**Addendum No. 1**

RE: Contract # C204119

WBS # 15BPR.15

Bridge #13 Over NE Cape Fear River On US-76/421

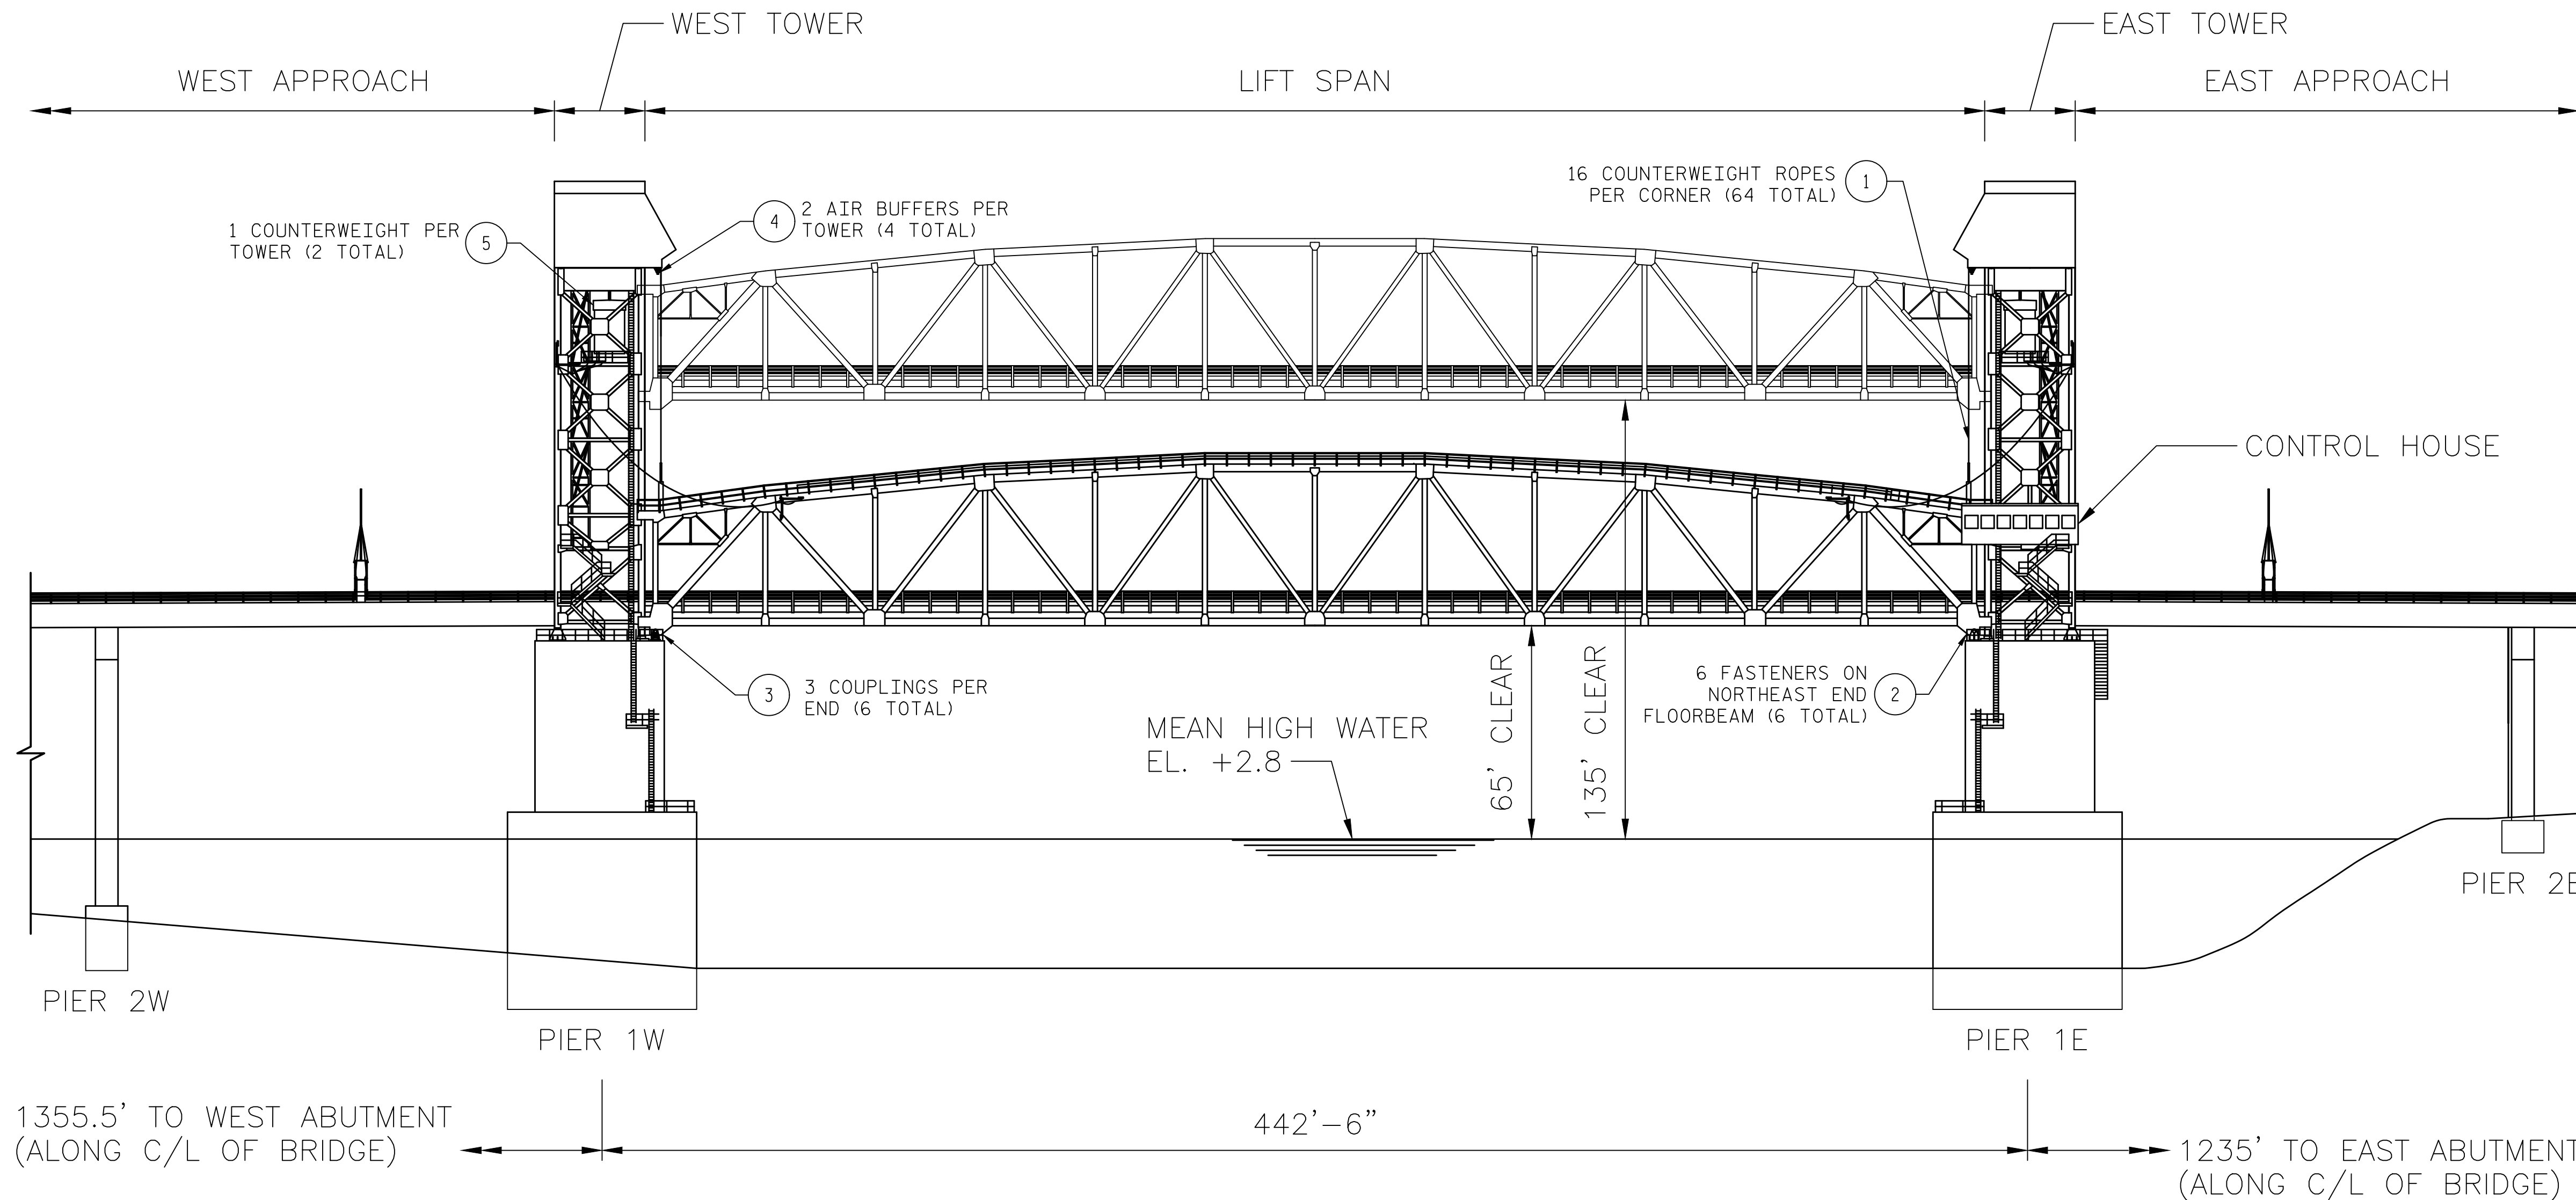
Sheet No.	Revisions
S-4	Revised to add the below noted pay item to the "Total Bill of Material" and to add two notes concerning same
M01	Added Note 1 in upper right hand corner concerning additional mechanical scope
MA-1 thru MA-10	New sheets added to include details for the "Mechanical Auxiliary Counterweight and Span Guide Repairs"
